Recommendation Report for Planning Permission for Works or Extension to a Dwelling

REF NO: AW/38/21/HH

LOCATION: 4 St Richards Drive
Aldwick
PO21 3BH

PROPOSAL: Single storey rear infill extension, first floor side/rear extension, conversion of garage to habitable use, porch canopy to front with pitched roof and alterations to fenestration

Date	January 2021	
Status	PLANNING	
Drawing Number	21-05- 02	Rev C
Scale @ A1	As indicated

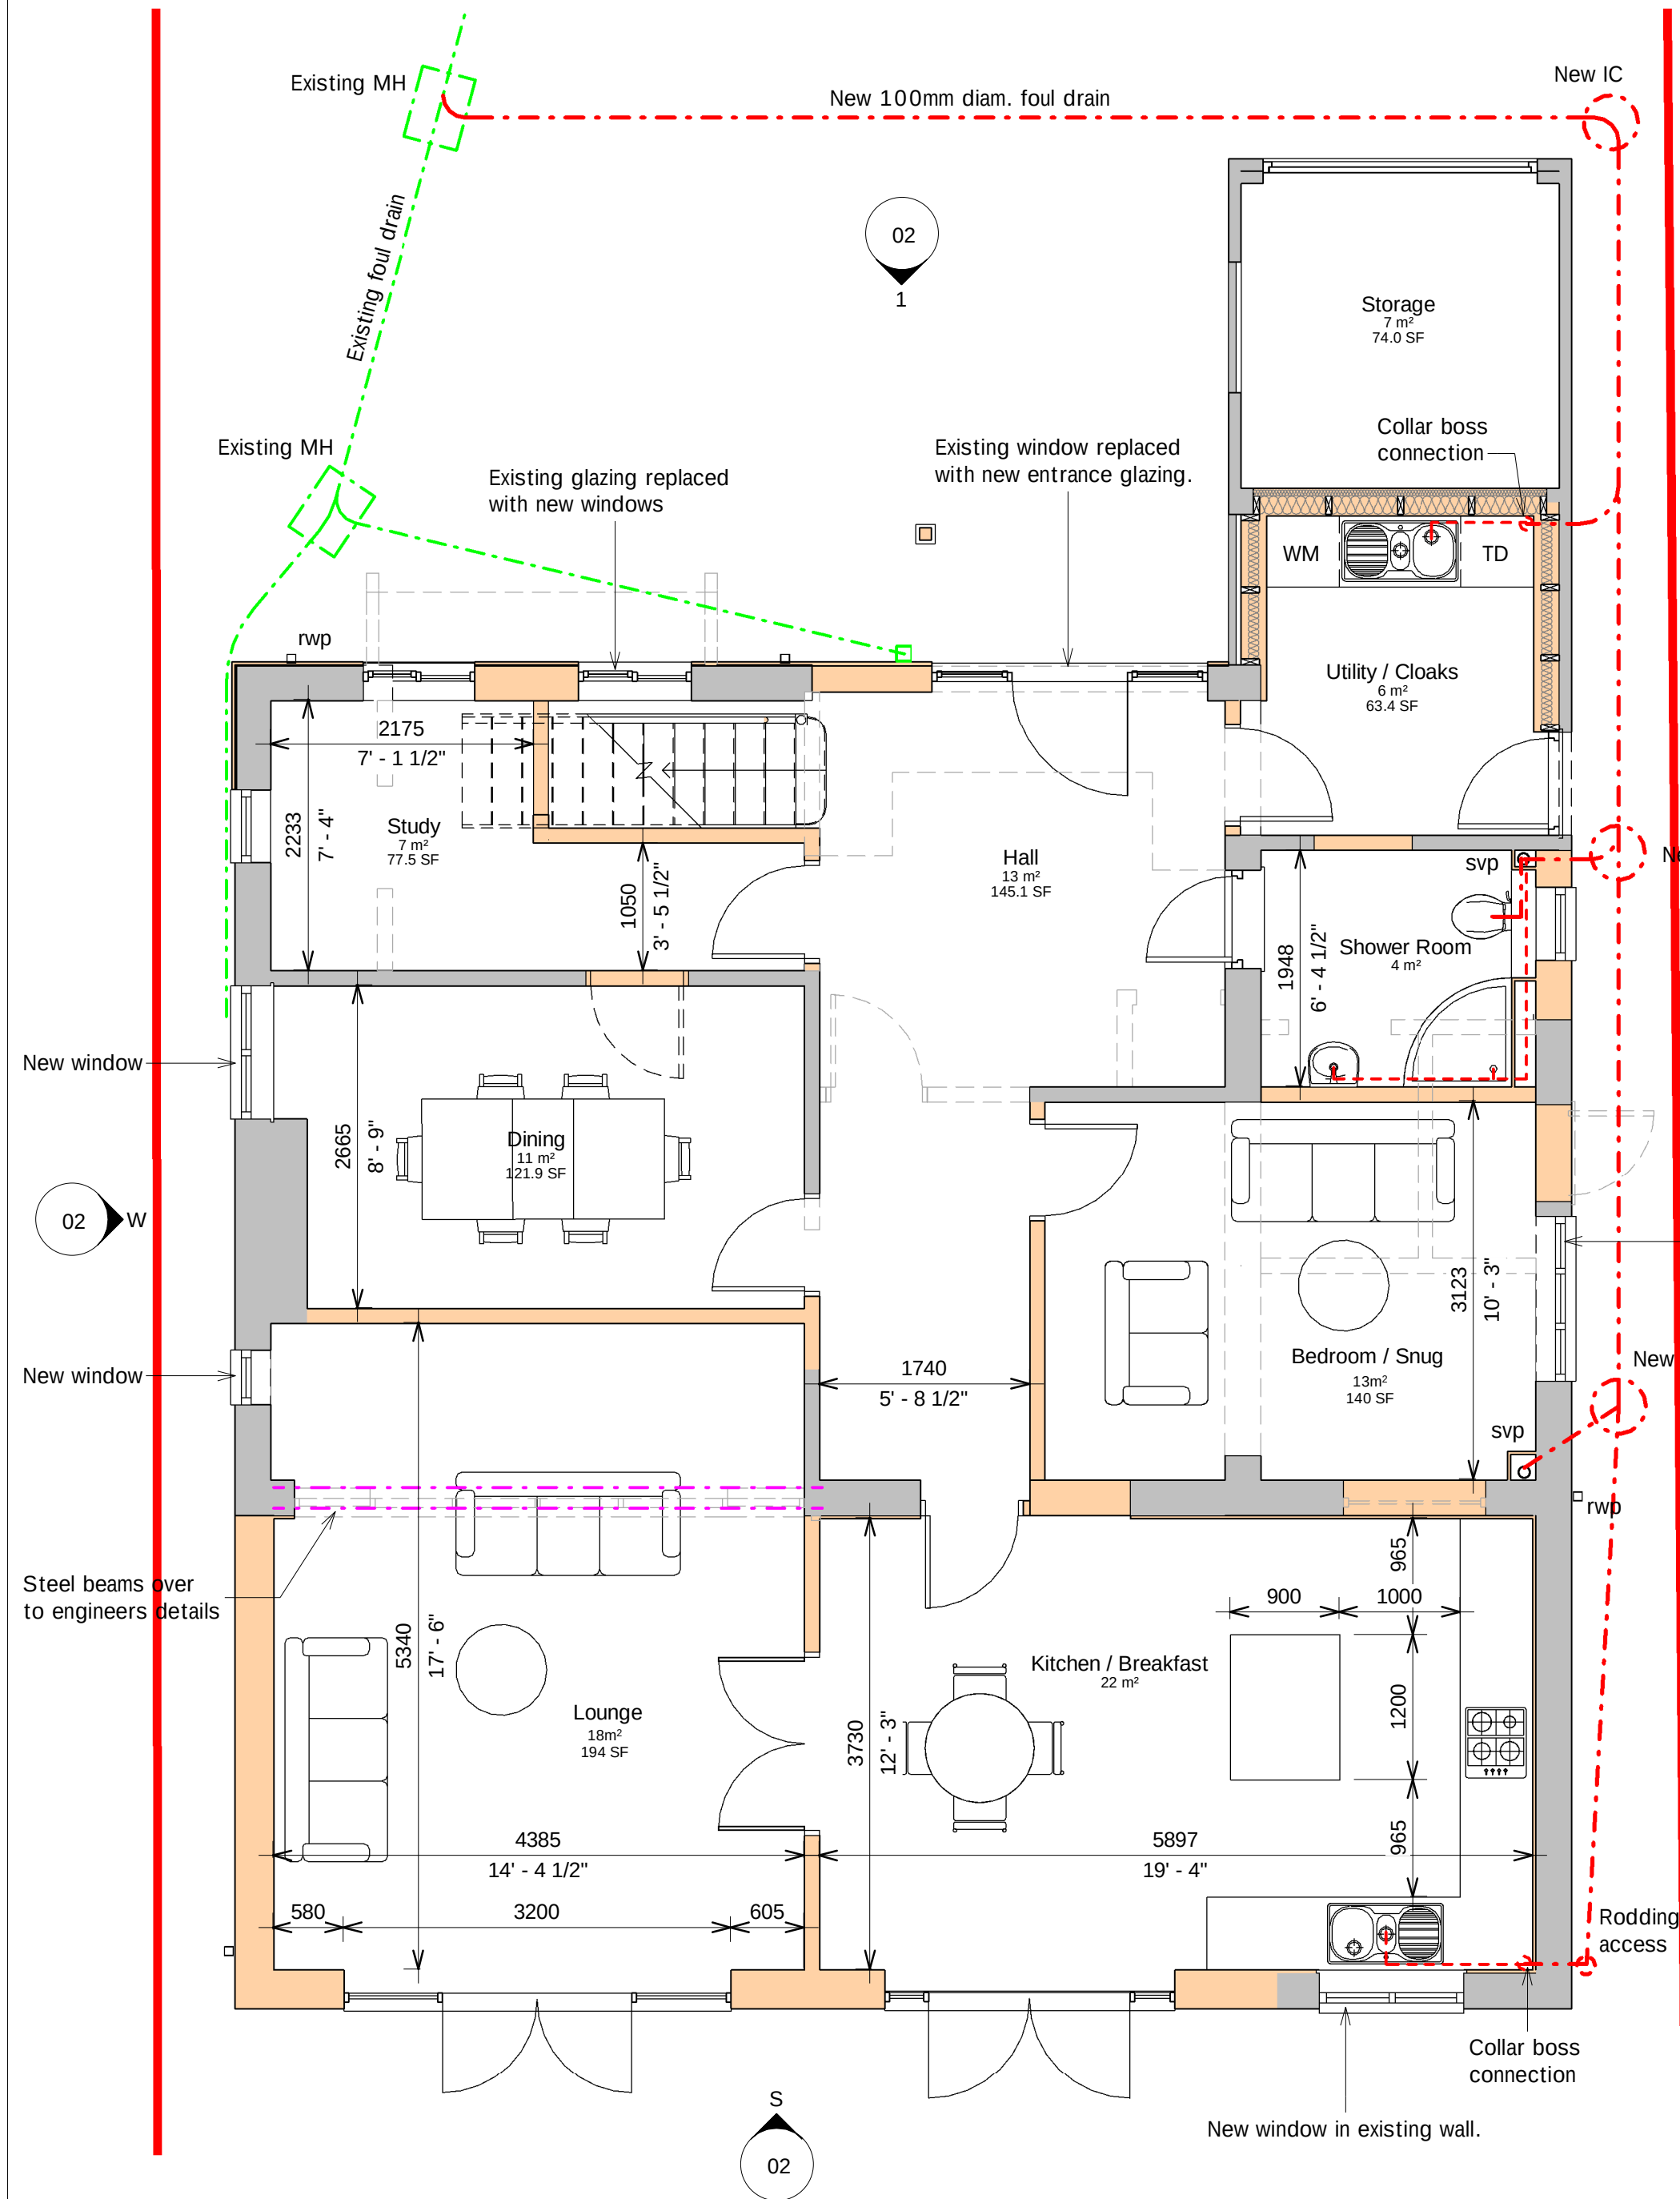
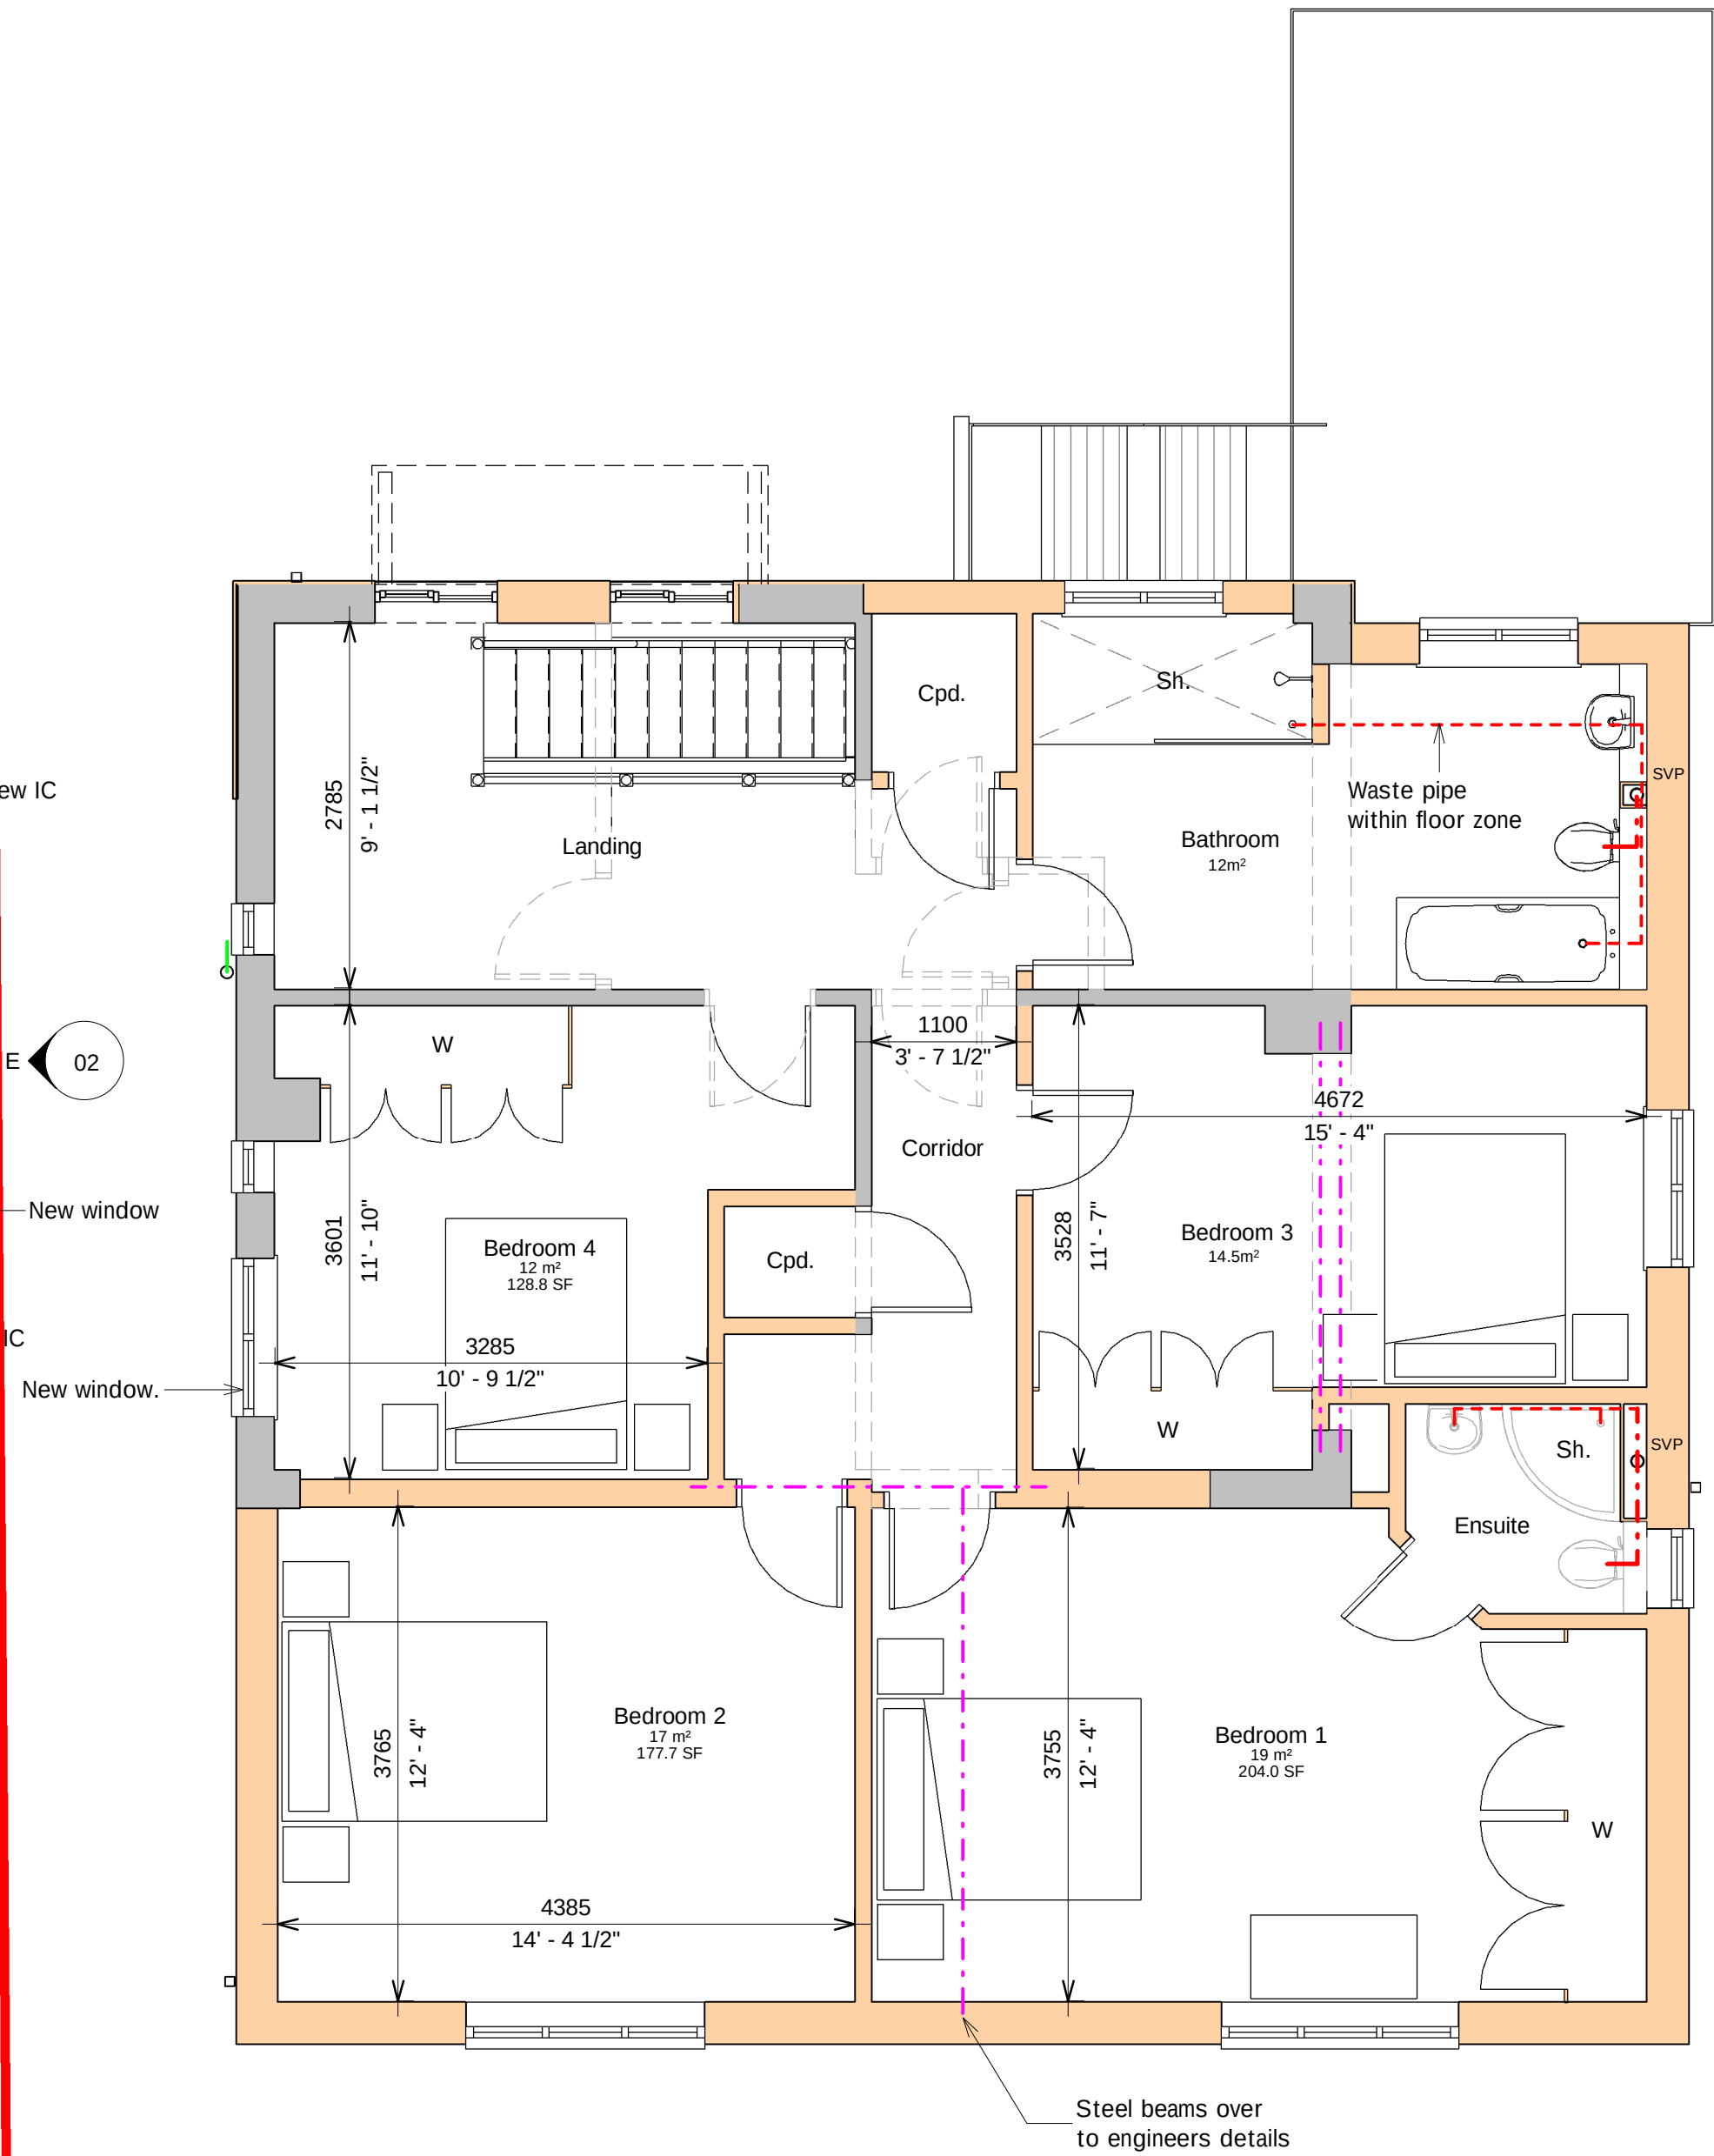
dwelling. The windows in the east would look towards a neighbouring dormer window and it is prudent to ensure these are obscure glazed.

Reason: To comply with Section 91 of the Town and Country Planning Act 1990 (as amended).
- 2 The development hereby approved shall be carried out in accordance with the following approved plans:
 - Proposed Extension Dwg No. 21-05-01
 - Plans and Elevations as Proposed 21-05-02 Rev C
Reason: For the avoidance of doubt and in the interests of amenity and the environment in accordance with policy D DM1 of the Arun Local Plan.
- 3 The new windows on the eastern elevation of the building shall at all times be glazed with obscured glass and to be fixed permanently non-opening to 1.7m.

Site Plan as proposed
1 : 200

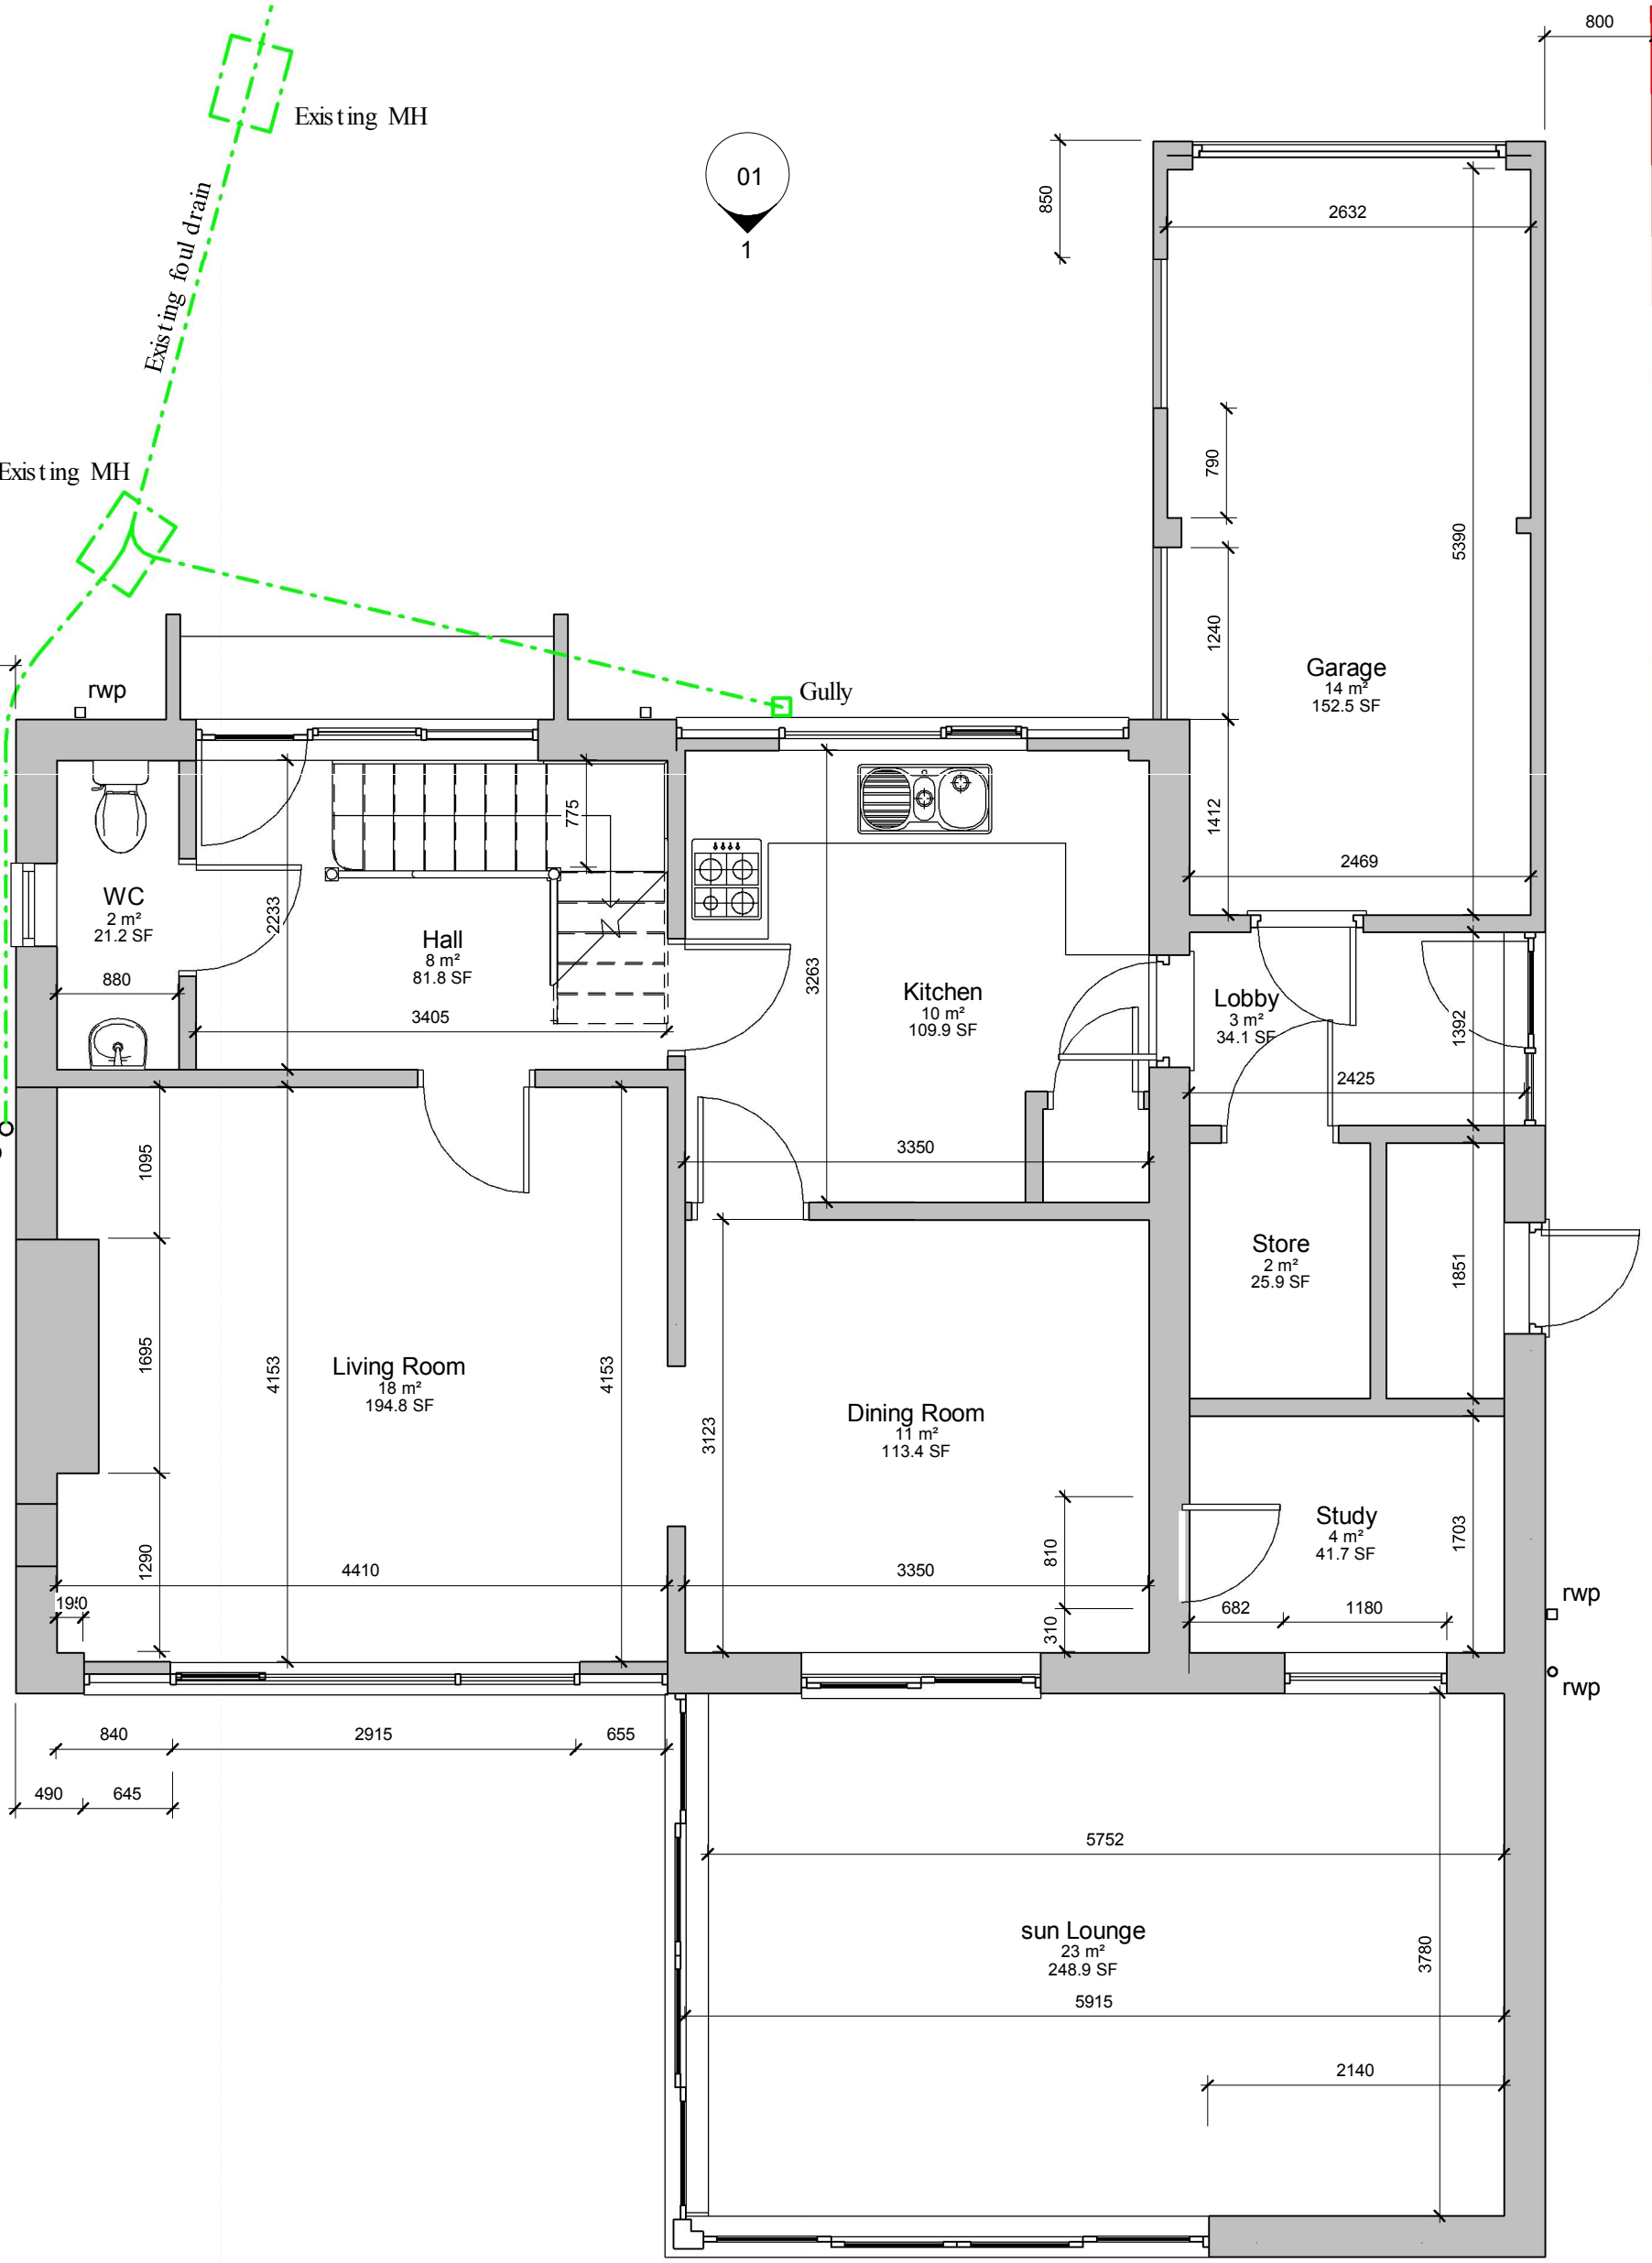
The site plan shows that the proposal would meet the parking demand generated of three spaces. These spaces are to the front of the property with a converted front garden into parking spaces. As such there is enough parking to cater for additional bedrooms at the property and loss of the garage. There is street parking in the local area.
